Thank you for your letter dated 9 November 2023 notifying me of the proposed erection of a single storey extension with roof terrace above, external alterations and extension of existing garage at 8 Boulder Gate, Marsden (application 2023/93205).

Having viewed the application, including plans and documentation on the Kirklees planning portal, I would like to object to the single storey extension with roof terrace and patio doors above – I do not have any objections to the internal alterations and the extension of the existing garage.

1:50 scale

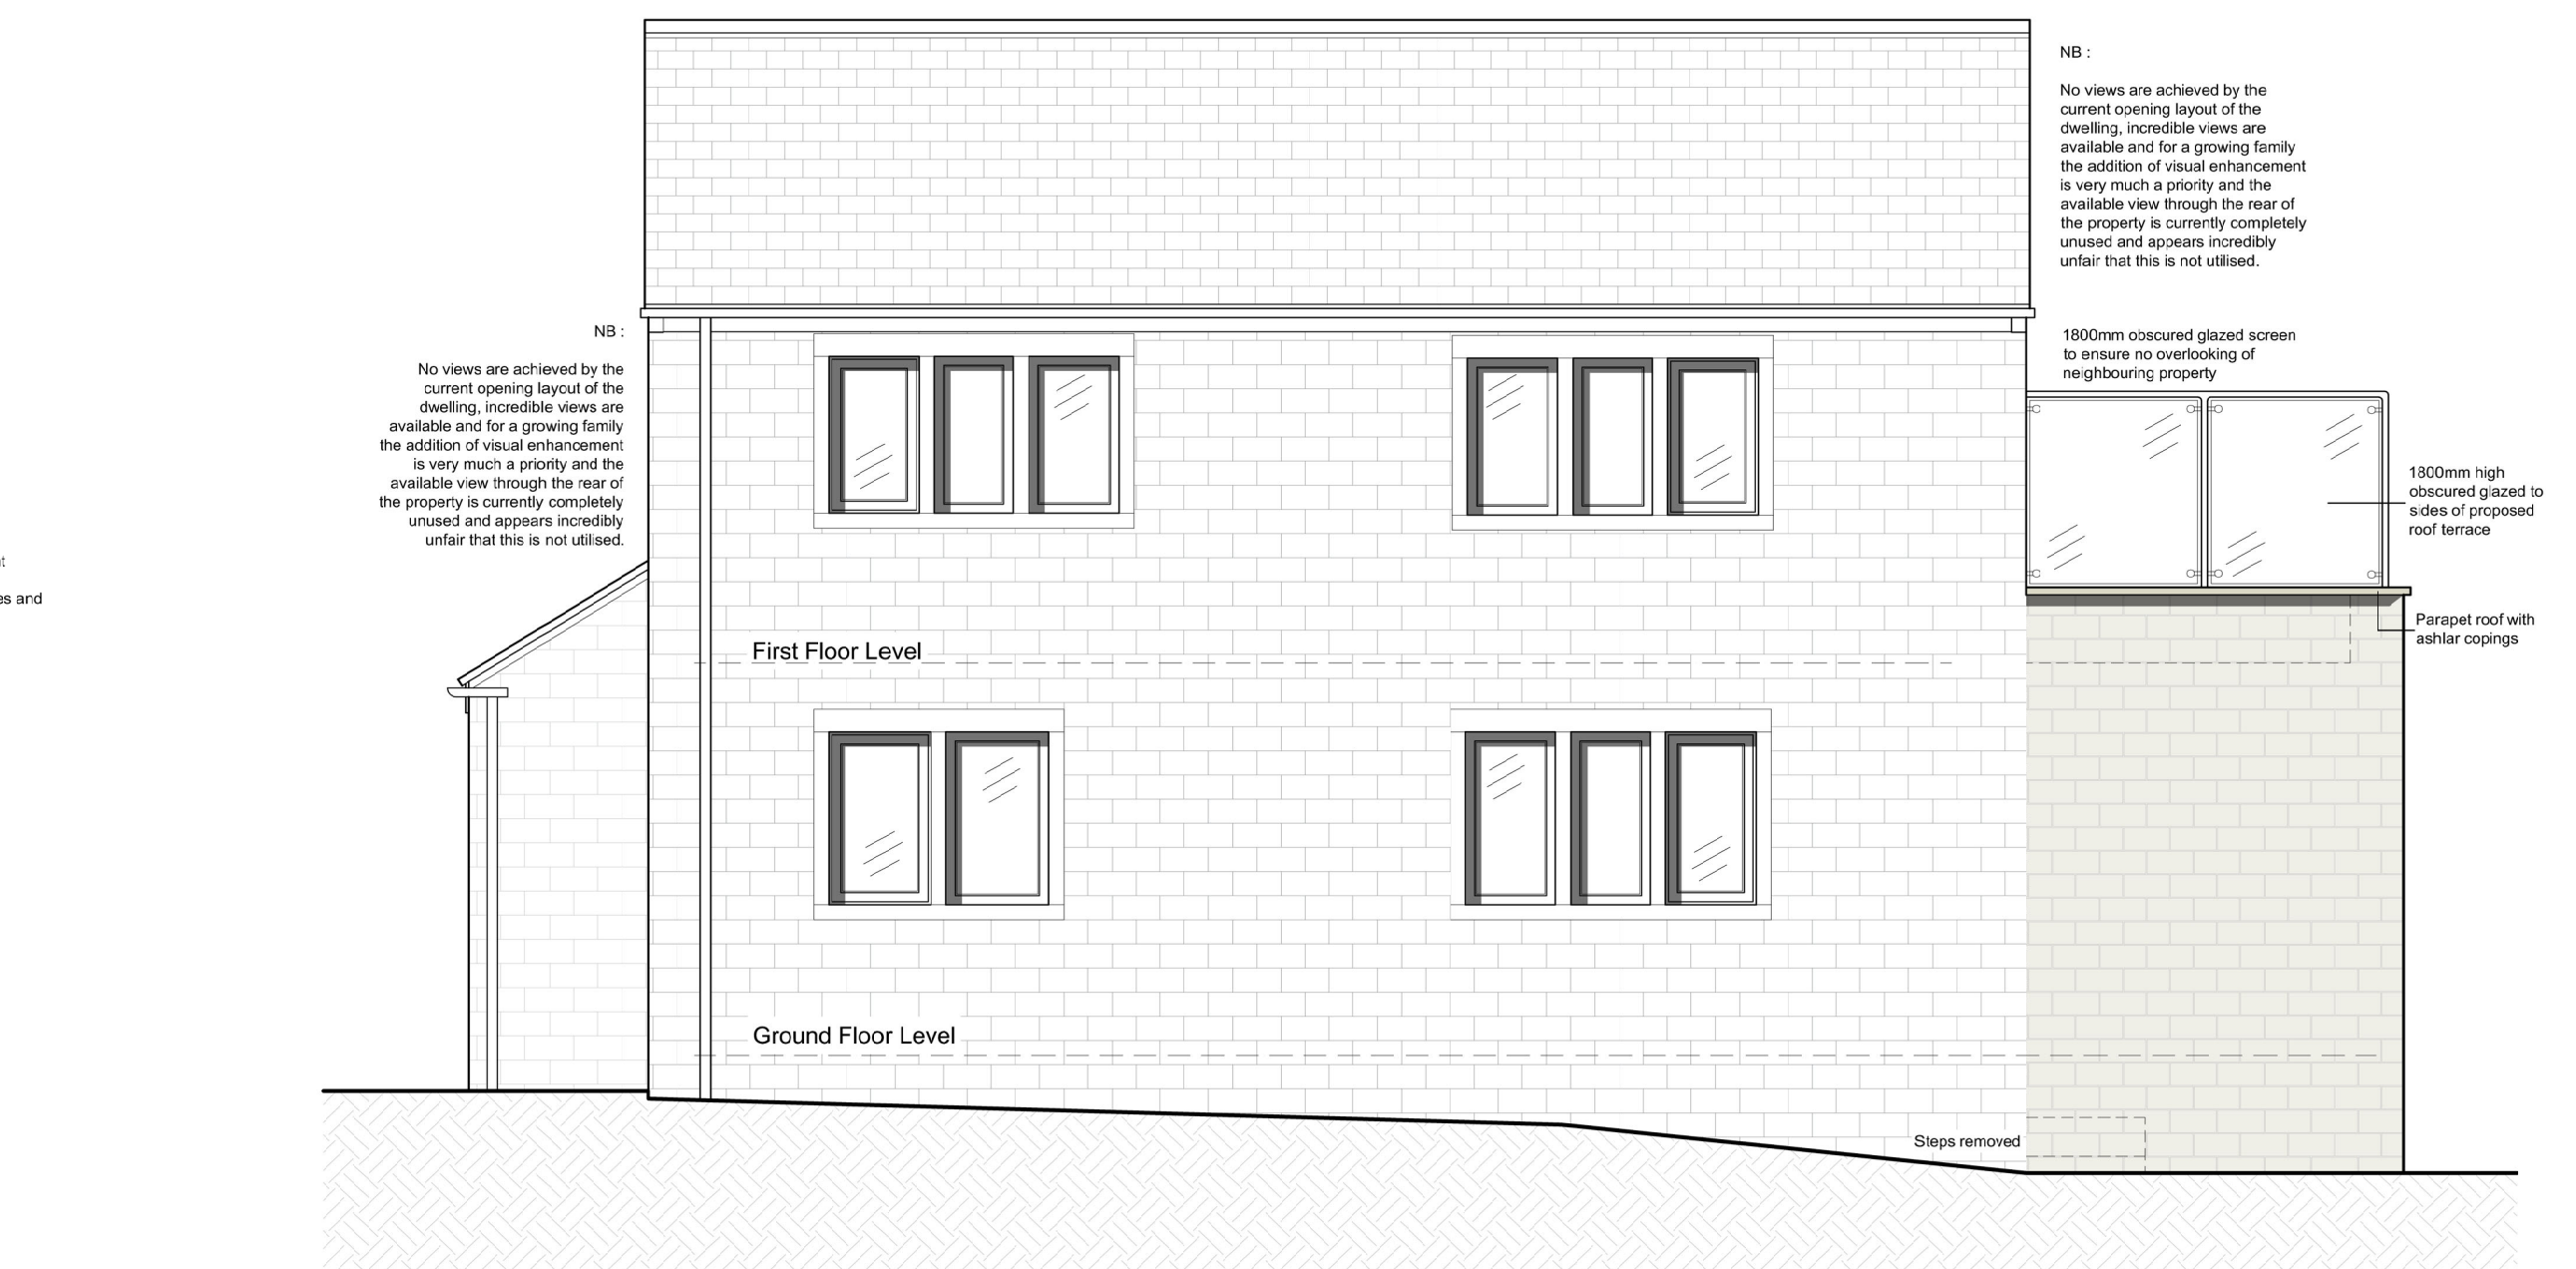
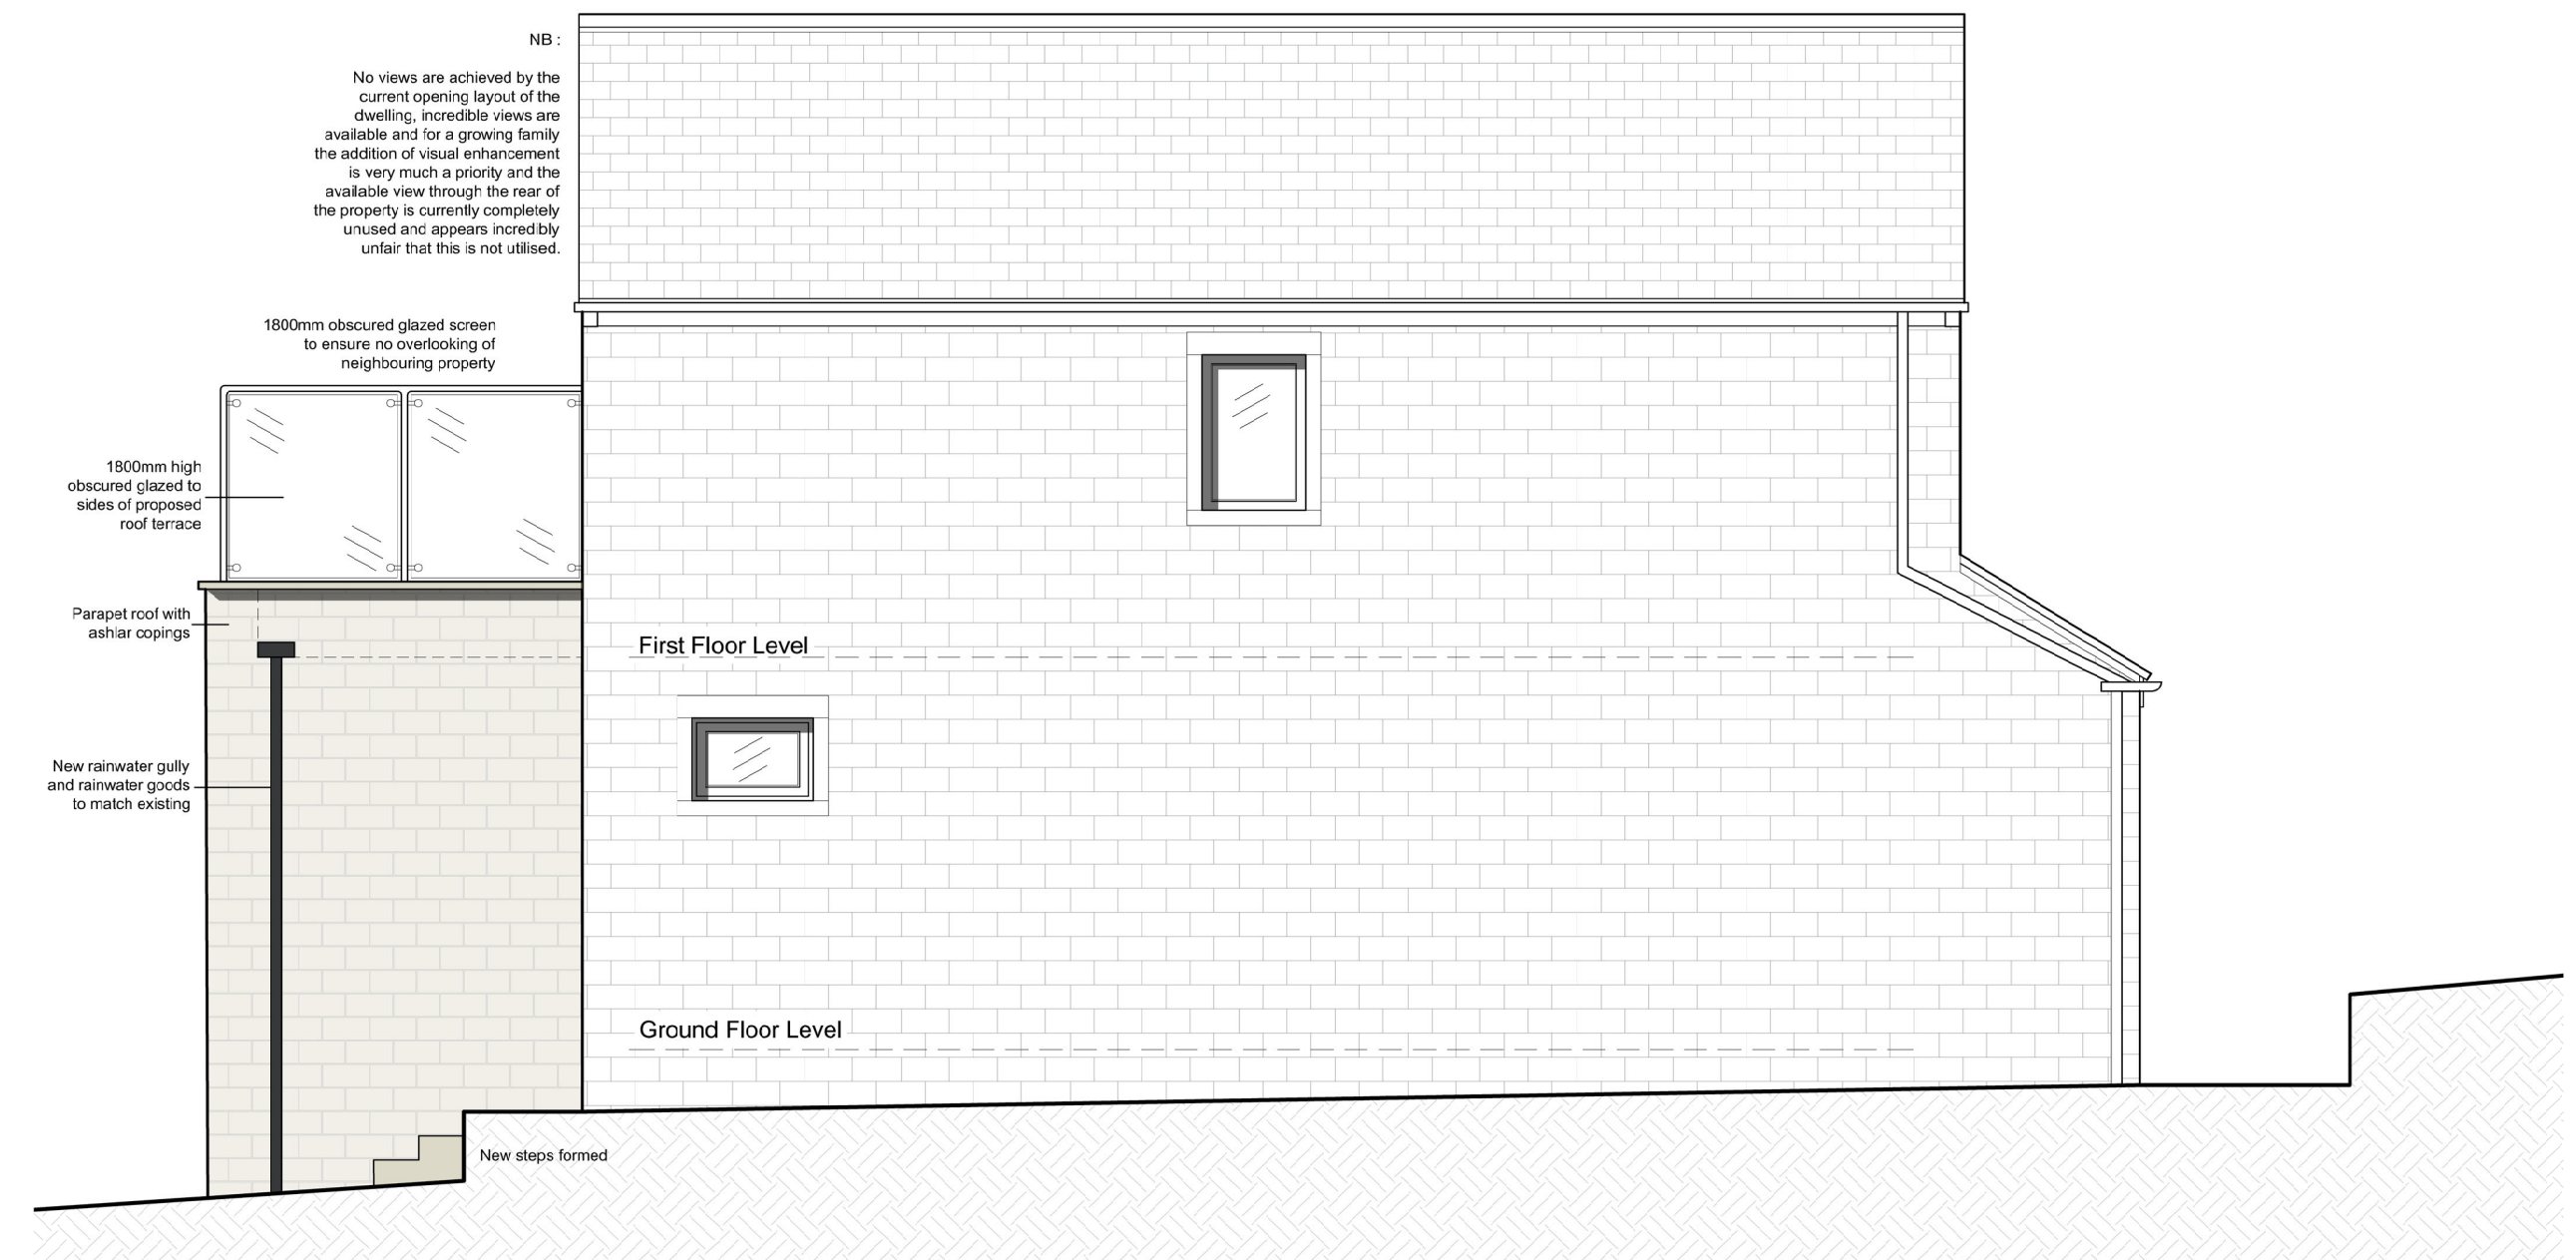
- b. There are no dimensions on the proposed extension – if shown with the correct orientation it appears that the extension will be right up to my boundary overlooking my bungalow and garden through the large picture window, roof terrace and patio doors.

- e. An 1800mm high obscured glazed screen is mentioned, I am unclear if this is 1800mm from the floor or top of the parapet wall.

- a. As I understand it, when shown with the correct orientation of 8 Boulder Gate, the proposal is to build a single storey extension up to my boundary with a large picture window overlooking my bungalow and garden. It is proposed to have a roof terrace above with parapet wall surround with ashlar copings and glazed screen. The proposal also includes for a new opening at first floor level with double patio doors again overlooking my property. The current garden steps are to be removed.

- b. Due to the steeply sloping ground away from my property, the ground floor of the 8 Boulder Gate extension, will be approximately 3 metres above the level of my drive at the front of their extension. An average person of 1.6 metres looking out of the ground floor picture window would be some 4.6 metres above my drive and on the roof terrace this same person would be some 7.2 metres above my drive.

- c. Similarly with my front garden – an average person of 1.6 metres looking out of the ground floor picture window would be some 3.7 metres above my garden and on the roof terrace this same person would be some 6.3 metres above my garden.

Location Plan

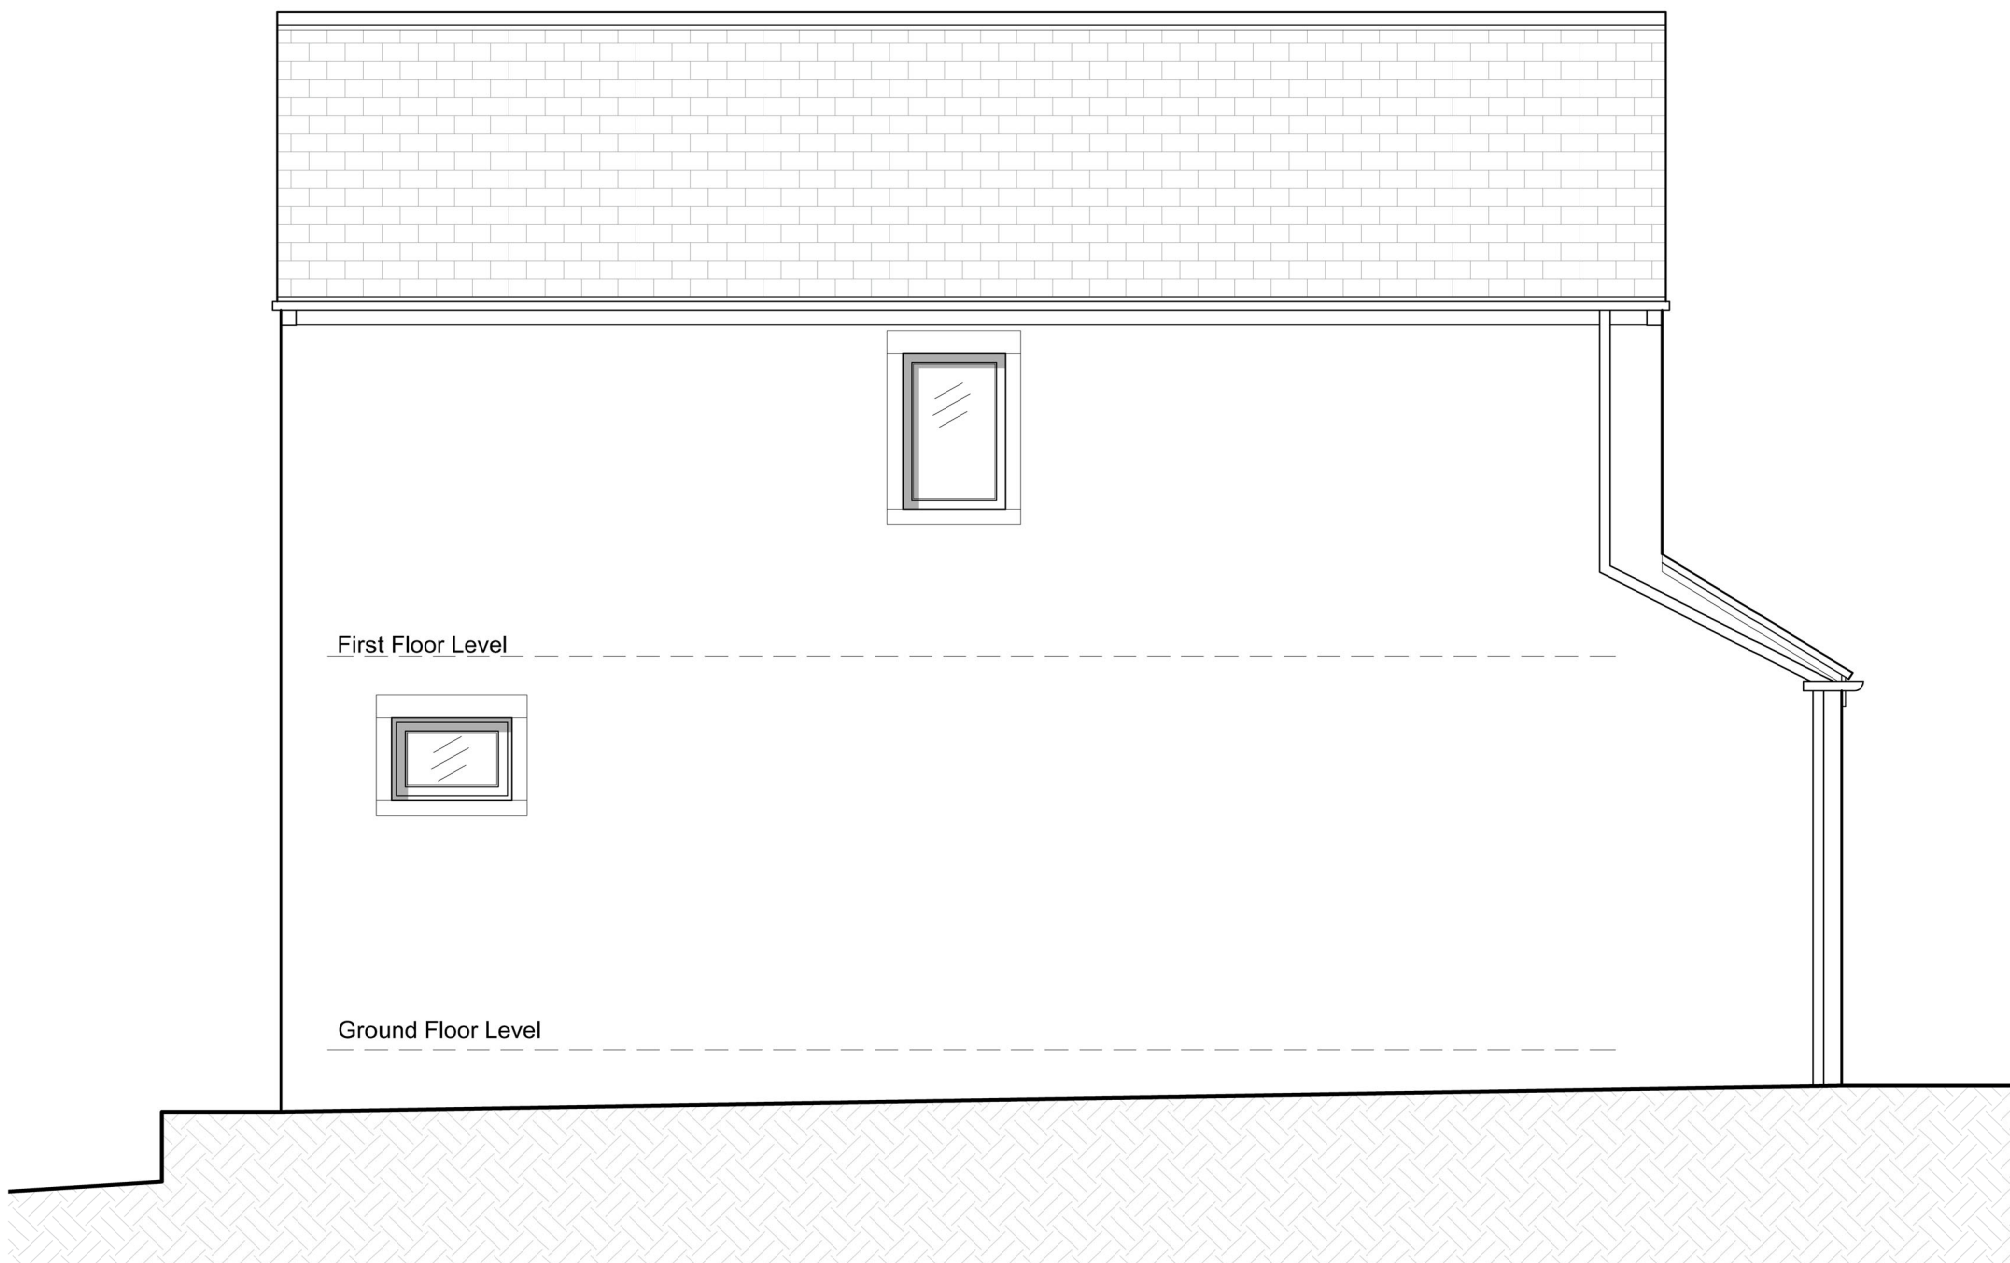
- a. The Location Plan (i.d. 1014916), Proposed Site / Block Layout (i.d. 1014915) and the Location Plan included on the Group Plans and Elevations as Existing drawing (i.d. 1014906) are all extremely misleading, showing an incorrect orientation of 8 Boulder Gate. The ridge of 8 Boulder Gate (that runs from west to east), is shown on the west side to be considerably above the horizontal facing away from my property. In reality, the ridge runs on a line below the horizontal, with the west elevation facing towards my property at Cartref and not across the valley towards Sparth as is shown on the drawings submitted by the applicant. This is obvious on site and can be seen clearly on the Kirklees Council KOMPASS map accessed via the 'view application on a map' link on the Kirklees planning portal and on Google Earth/Maps.
